Re: BusConnects Belfield/Blackrock to City Centre Core Bus Corridor Scheme
Co. Dublin

Re: Submission for Bus Connects Belfield/Blackrock to City Centre Core Bus Corridor Scheme – Nutley Lane Section

BusConnects Corridor 14 Scheme and CPO

Nutley Lane Section,

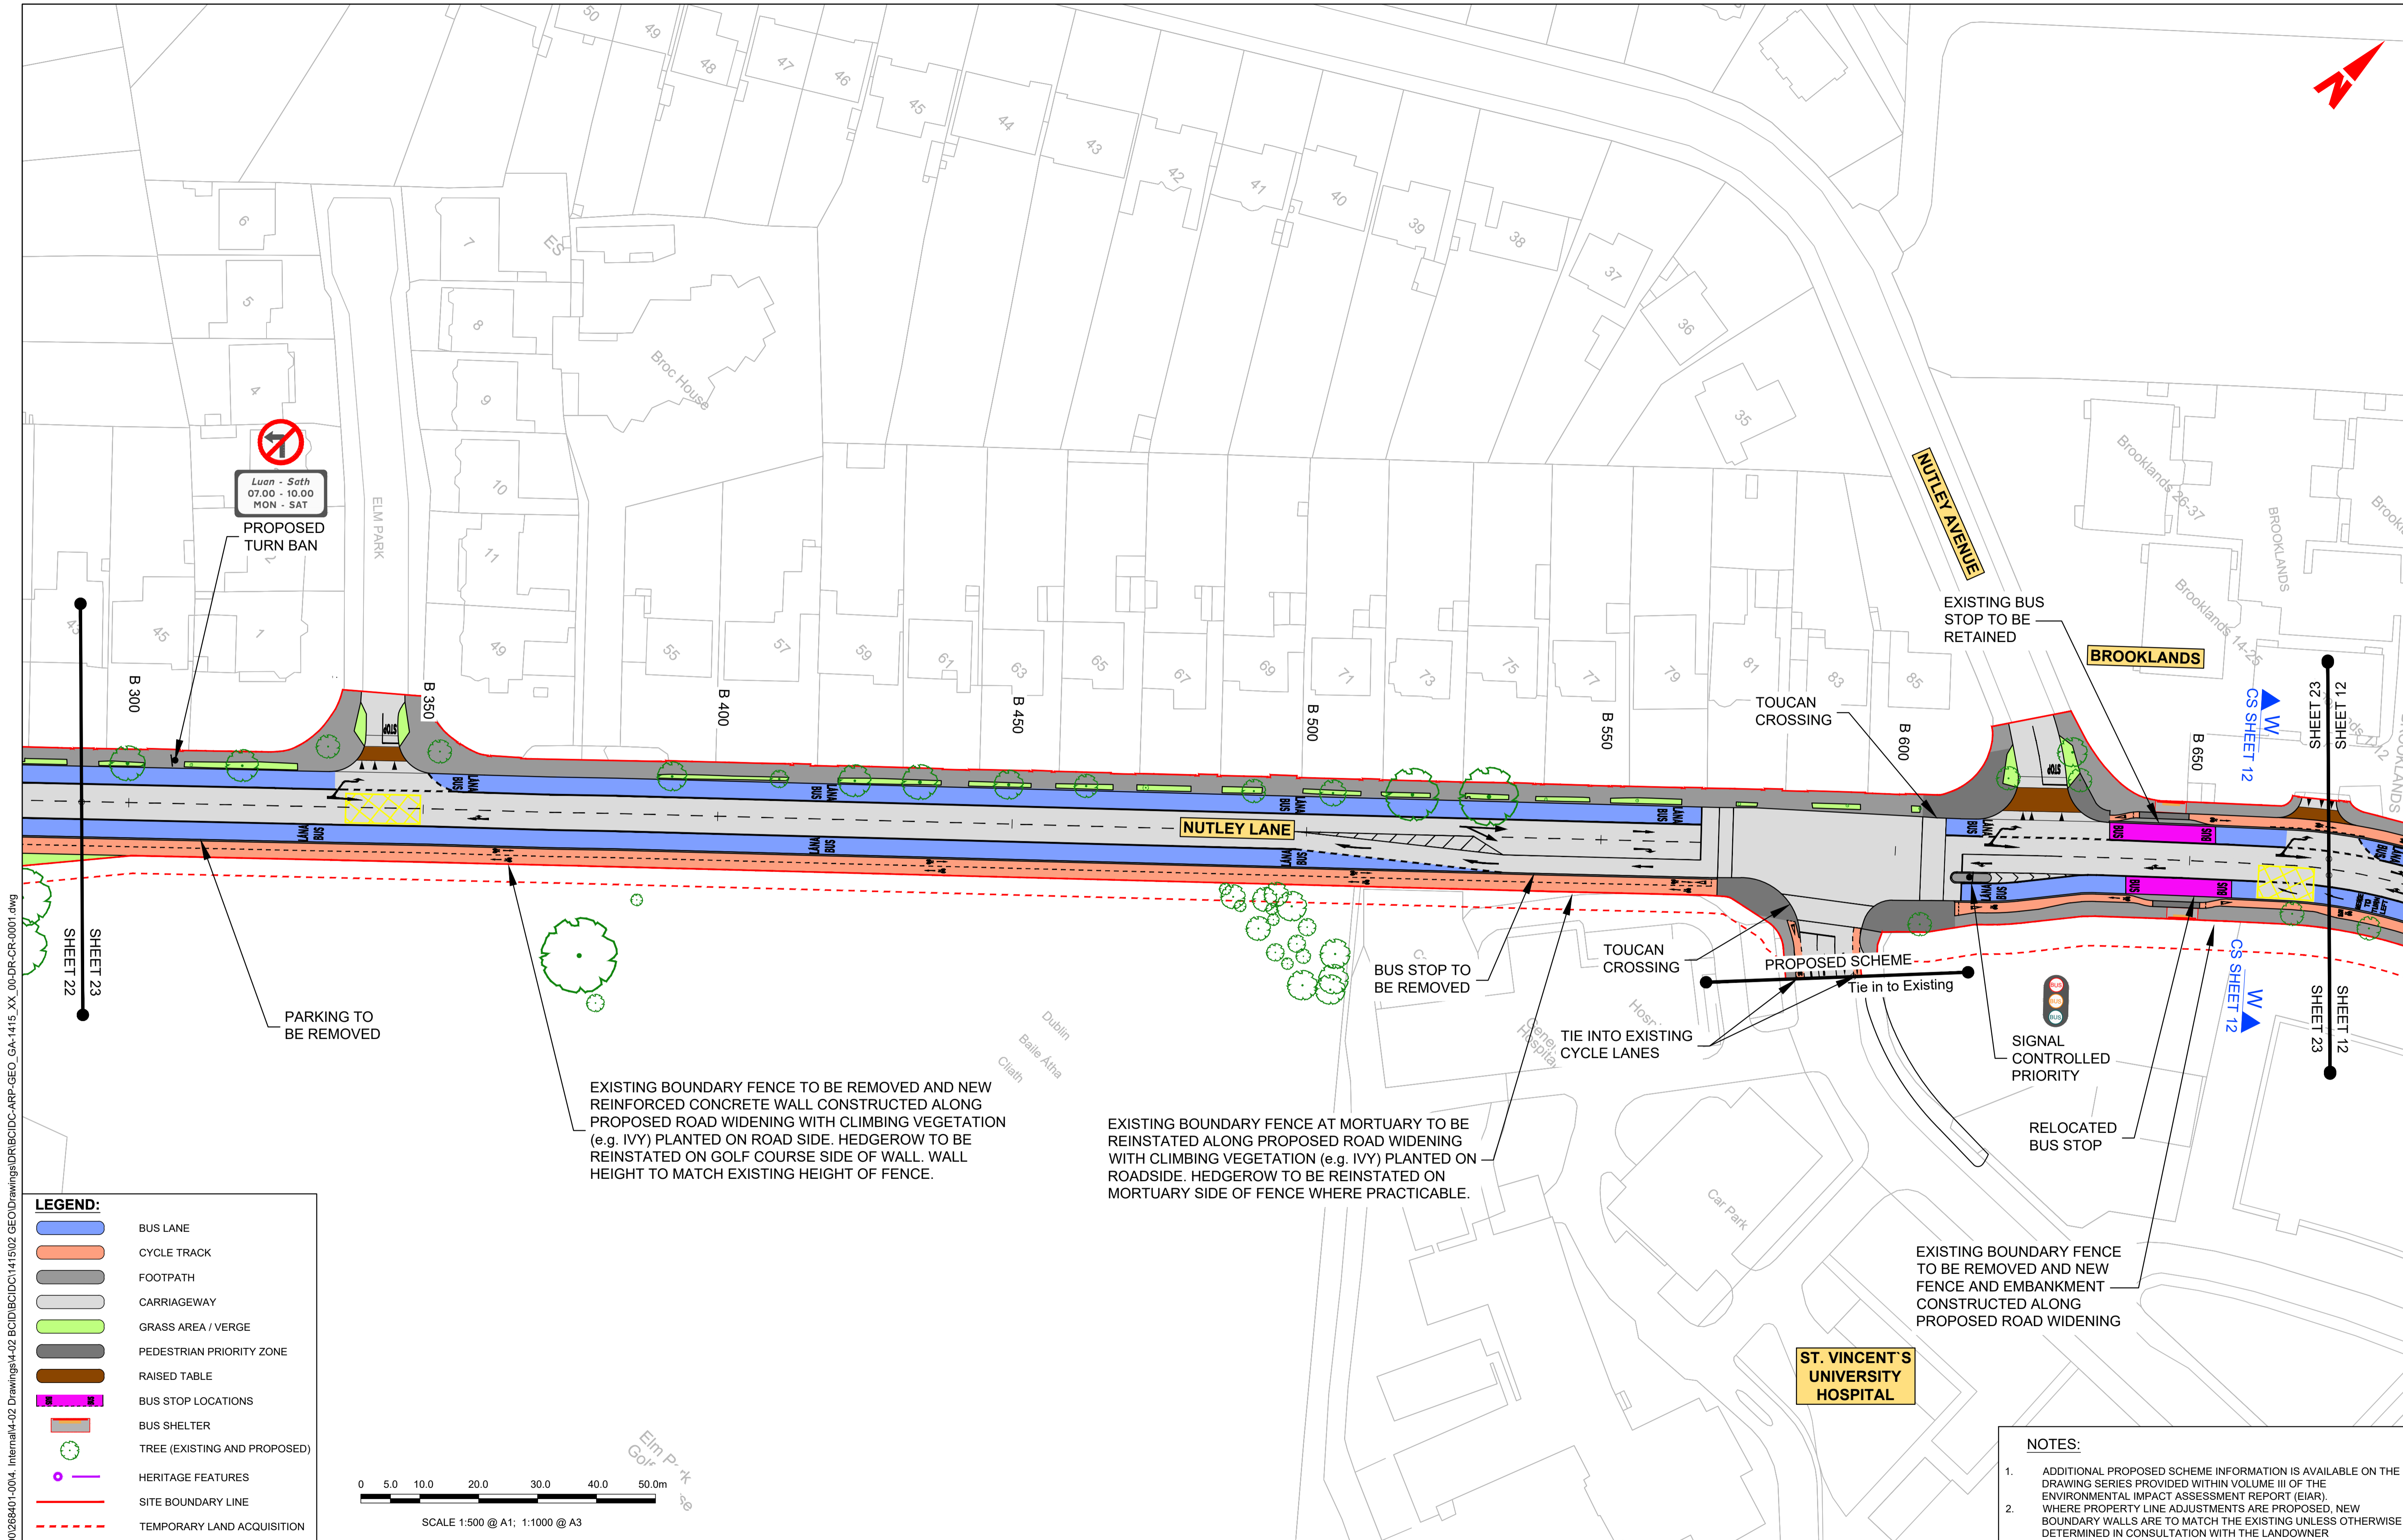
- Compared to the indicated simple “splay” indicated for this gate on Sheet 22 of the proposed scheme submitted to ABP, there needs to be sufficient allowance made for visibility of bikes, buses, service and emergency vehicles and cars driven by members/visitors exiting that gate.
